31 March 2014

**Determination Report
Sydney University Abercrombie Precinct Redevelopment (MOD 3)**

2. THE SUBJECT MODIFICATION APPLICATION (MOD 3)

Ground Floor Plan
1:200@A1
11.10.13
4001_DA02-D

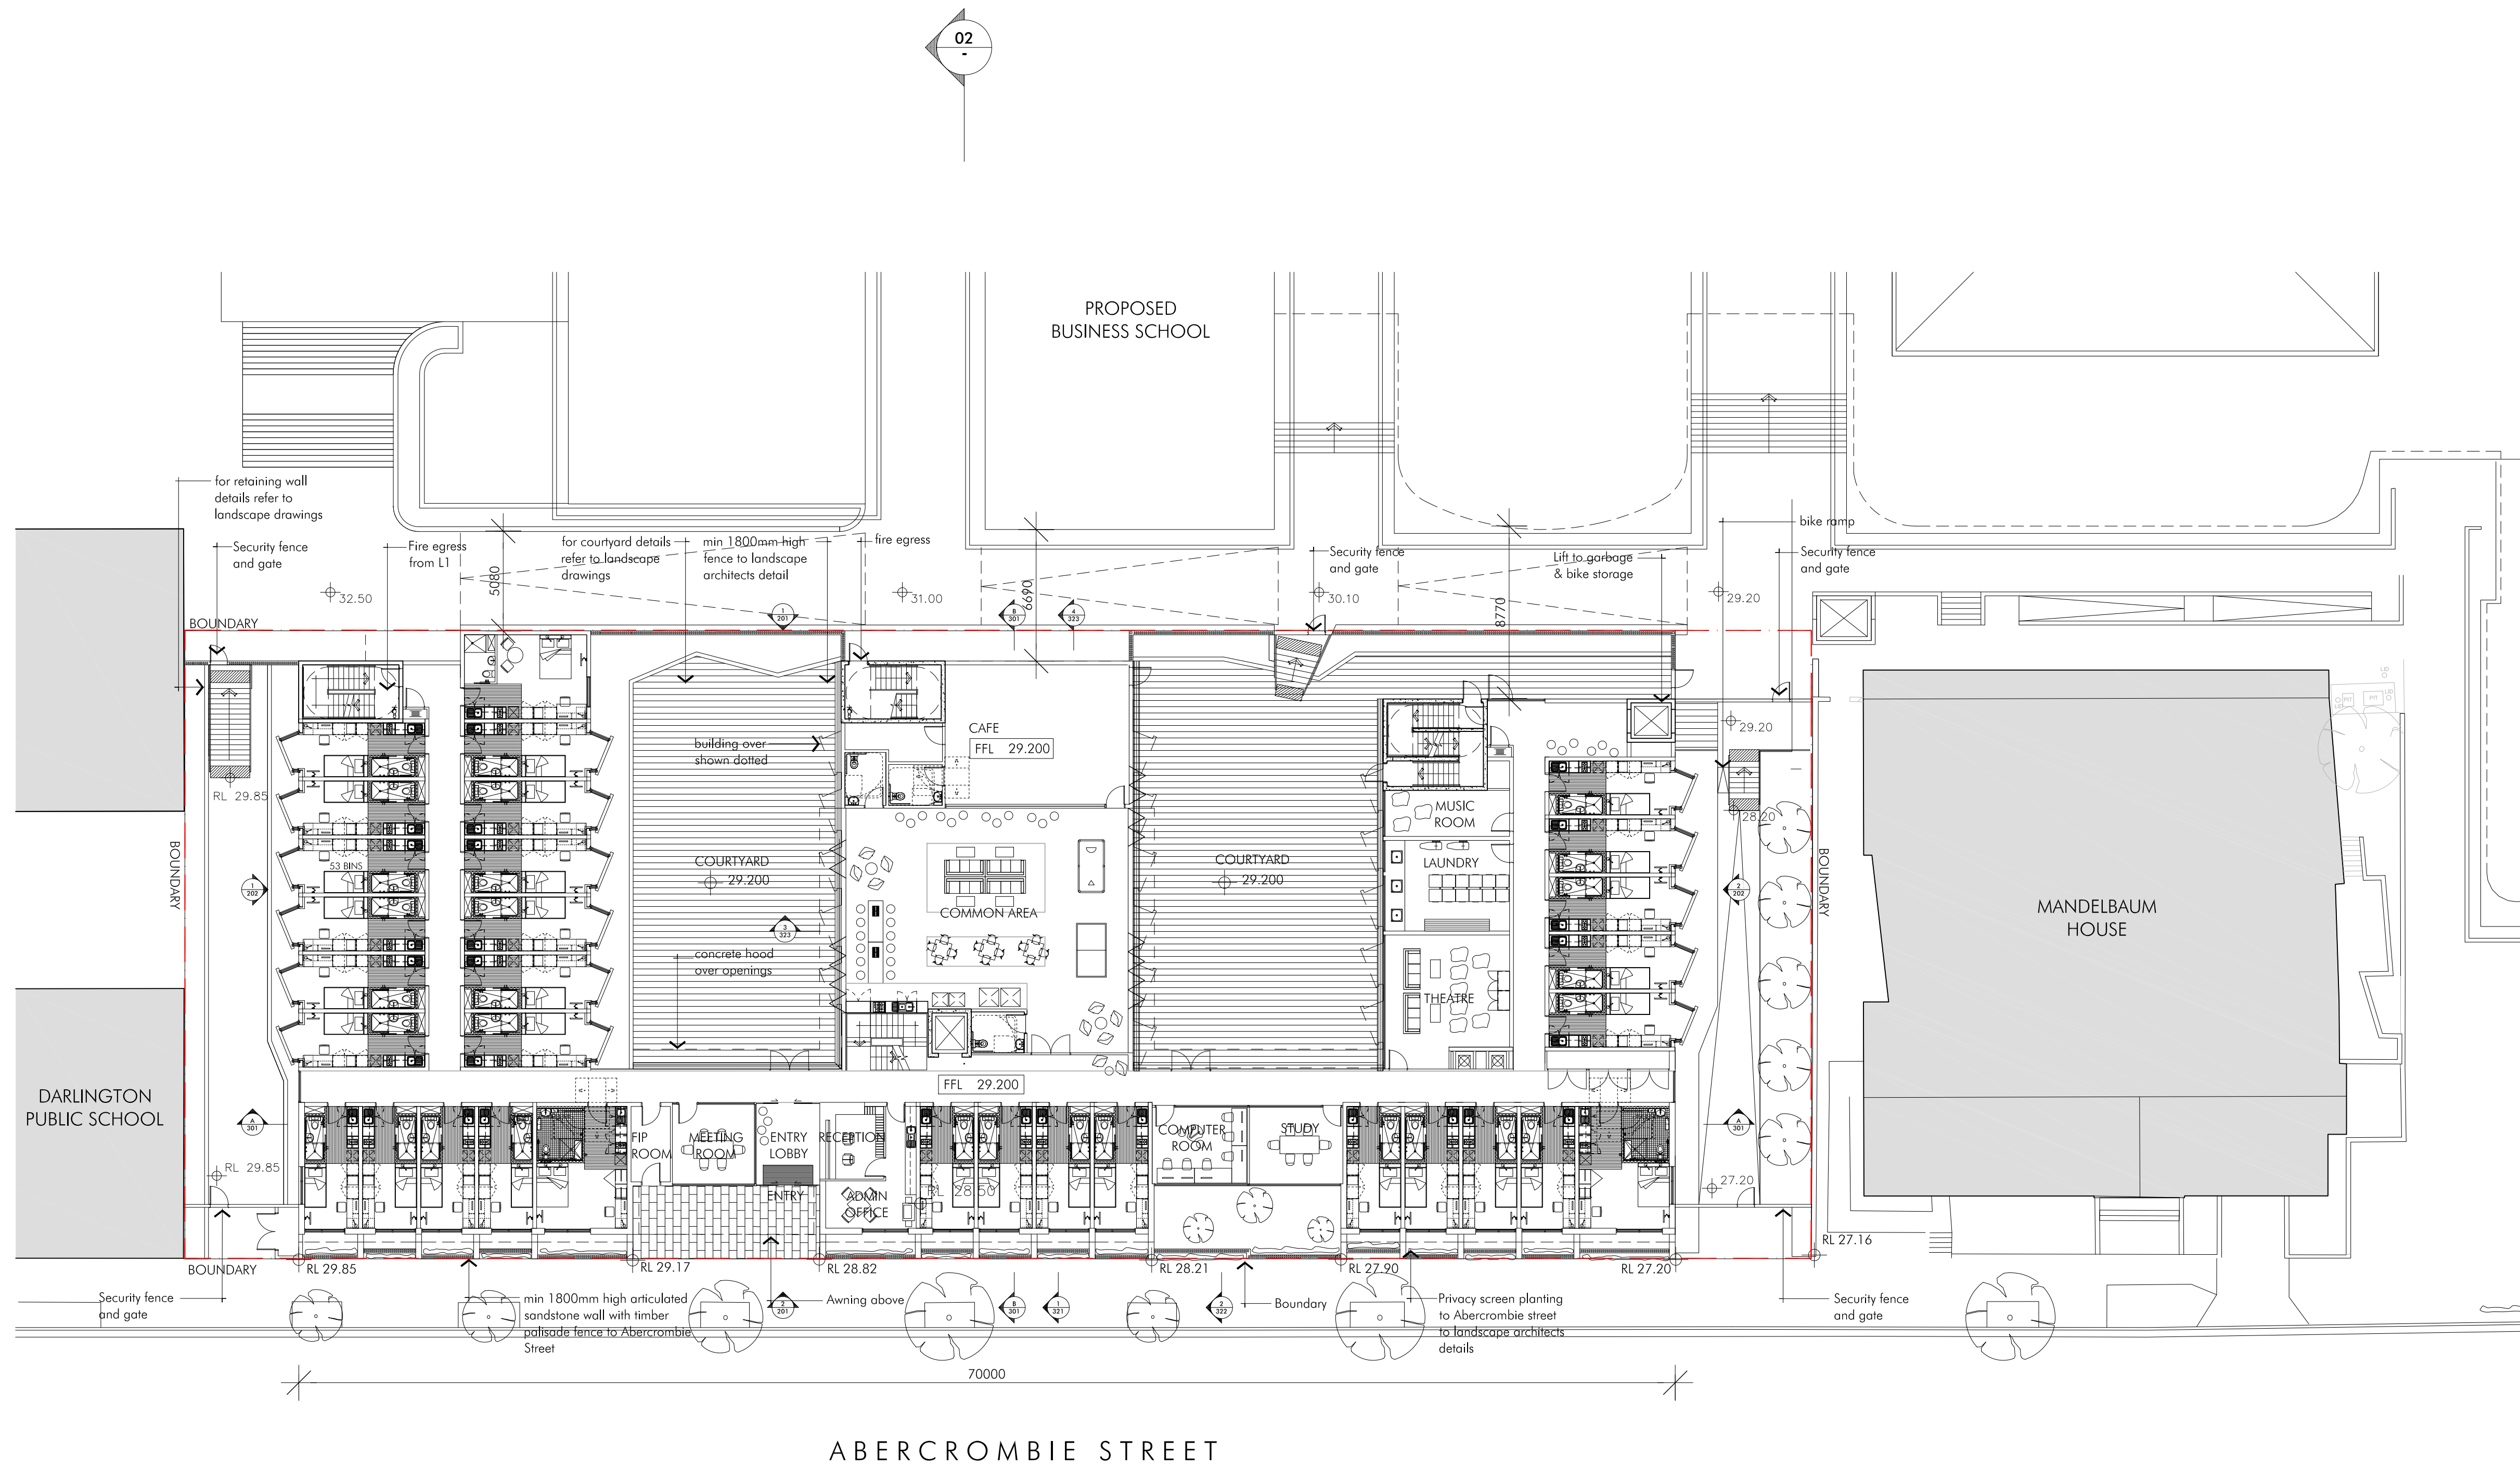
The community's concern about the access paths on both sides of the building mainly relates to safety and security issues. The Commission has carefully reviewed the ground floor plan and sought the proponent's confirmation that there will be a security fence with a door at both ends of the access paths. The doors will be locked when it is dark. The Commission is satisfied that the provision of security fence and gate (with CCTV camera) will address the security and safety issues raised by the community and Mandelbaum House.

Mandelbaum House requested that the lift opening face away from Mandelbaum House to minimise noise and amenity impacts on its residents. The Commission requested the proponent to reconsider the lift opening at ground level. In response the proponent advised that it would re-direct the opening to the north as shown in the plan below. An amended plan to reflect the change shall be submitted to the satisfaction of the PCA. A condition is imposed accordingly (Condition B31).
